Reference: Engineering Services
Permit # SFD2401-0047
Serenity - Lot 125
369 Serenity Walk Parkway
Fuquay-Varina, NC 27526
TE&D Project No.: 2401-020118_A

1. Inspect and analyze the damaged roof truss bearing at the rear wall.

**SOUTH**  
**B326-B**  
**RFP-2**  
 BLAKESTONE  
 RALEIGH

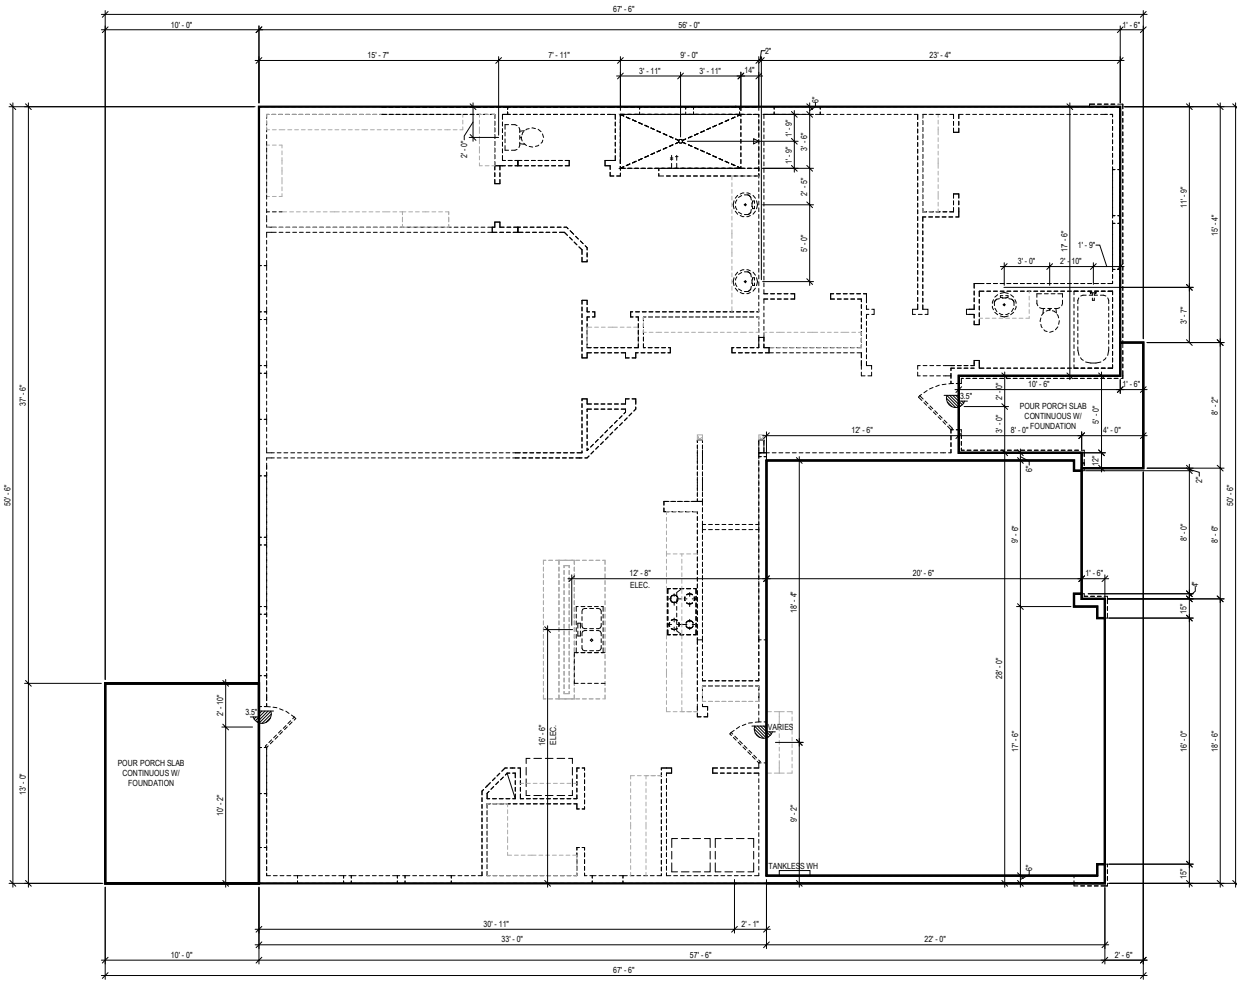
1. Truss A03 (2nd from the right wall) was damaged at the rear bearing end. The truss was repaired with a 2 x 4 x 6'-0" scab fastened with (2) rows of 10d nails at approximately 4" o.c. Based on our observations and analysis, the repaired truss will provide the required support for the anticipated loading conditions.
